**PART 3A DEVELOPMENT – ROYAL RRINCE ALFRED HOSPITAL – NORTH WEST
PRECINCT – 67-73 MISSENDEN ROAD AND 25 LUCAS STREET, CAMPERDOWN –
ENVIRONMENTAL ASSESSMENT– PROPOSED NEW MULTI-STOREY HOSPITAL
BUILDING AND PARKING – MAJOR PROJECT 10_0166**

The exhibited environmental assessment for this proposal has been reviewed with particular reference to the Heritage Impact Statement prepared by City Plan Heritage dated July 2012, consistent with Director General Requirement 7 requiring the proponent to assess the significance of and impact on heritage items and areas in the vicinity. The following Heritage Council comments are accordingly provided with regard to heritage issues.

MISSENDEN ROAD AND LUCAS STREET VIEW

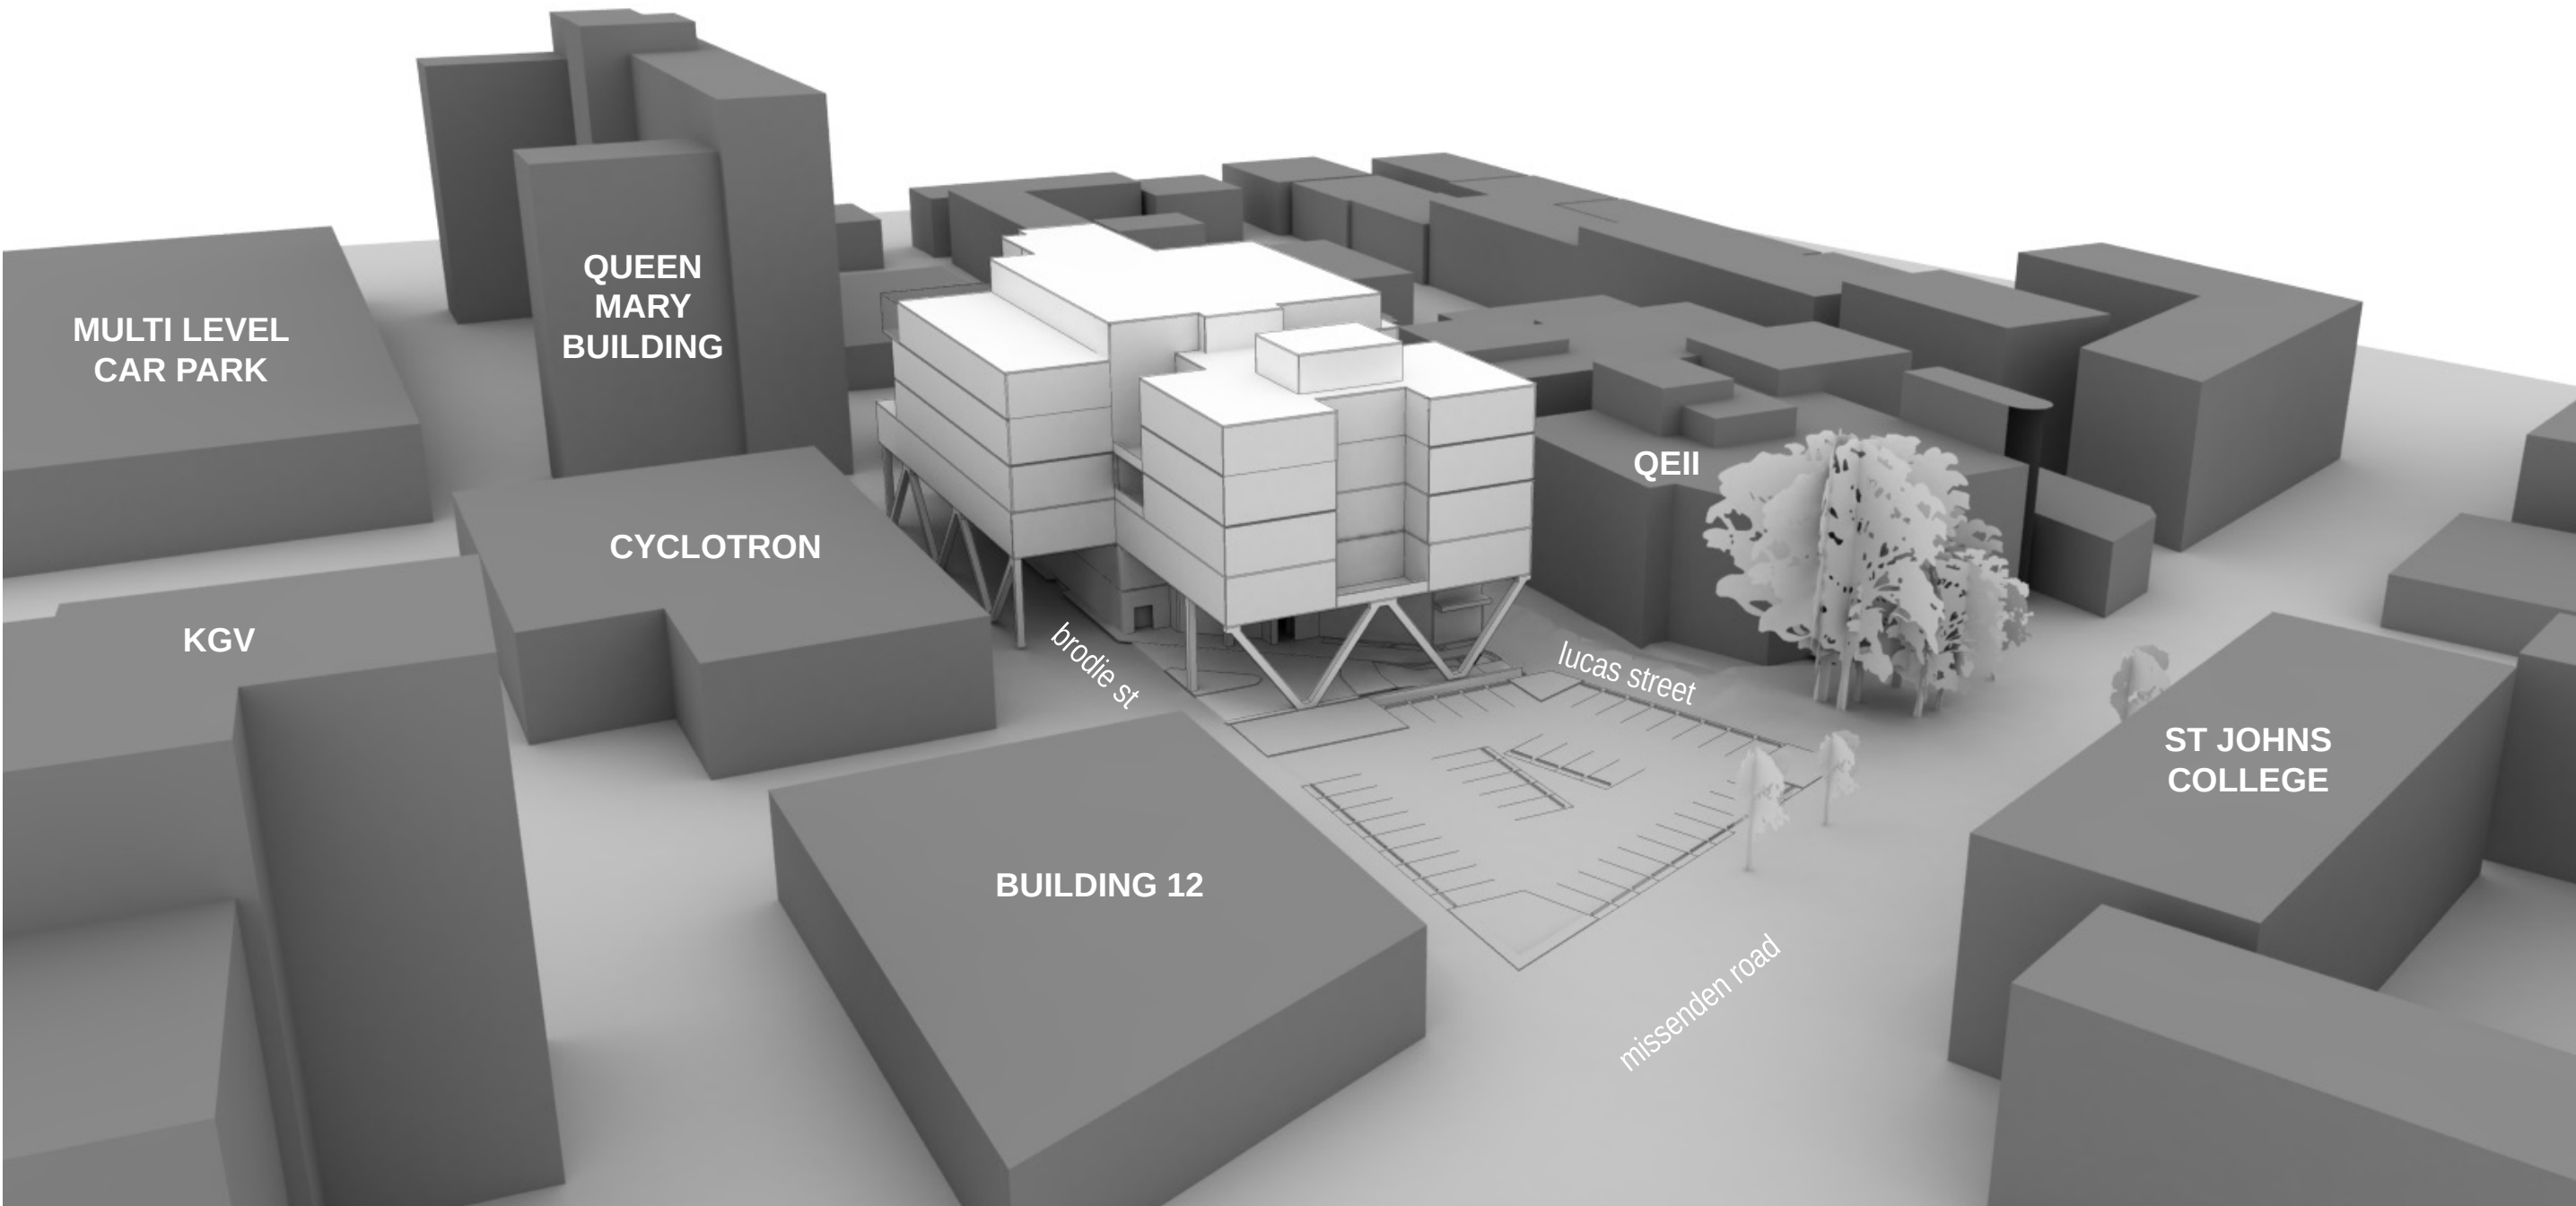
While the Heritage Council notes these conclusions of the Heritage Impact Statement, it is considered that buildings 11 and 12 (on the adjoining site) may have a contributory role in the significance of the surrounding urban landscape which, in the opinion of the Heritage Council, is itself likely to be of some significance containing such buildings as the Sancta Sofia and St John's Colleges, King George V and Prince Alfred Hospital, as well as St Andrews College and some important remnant industrial buildings. The elimination of a building form on Missenden Road could also have some impact on the streetscape that currently is largely comprised of buildings directly on the street alignment.

It is therefore recommended that the Heritage Impact Statement be amended to consider the potential impact the demolition of these buildings may have on the surrounding heritage character of the area and especially the streetscape of Missenden Road.

1. The Statement of Heritage Impact is amended to consider the potential impact the demolition of these buildings may have on the surrounding heritage character of the area and especially the streetscape of Missenden Road.
2. Any recommendations from the City of Sydney to mitigate impacts on heritage items and areas of local heritage significance.
3. In the event substantial intact archaeological relics are discovered during excavation, work must cease in the affected area and the Heritage Council notified in writing in accordance with section 146 of the Heritage Act 1977. A suitably qualified and experienced archaeologist must be contacted to assess the finds and, depending on the nature of the discovery, archaeological recording, excavation and revised interpretation may be required prior to works commencing.
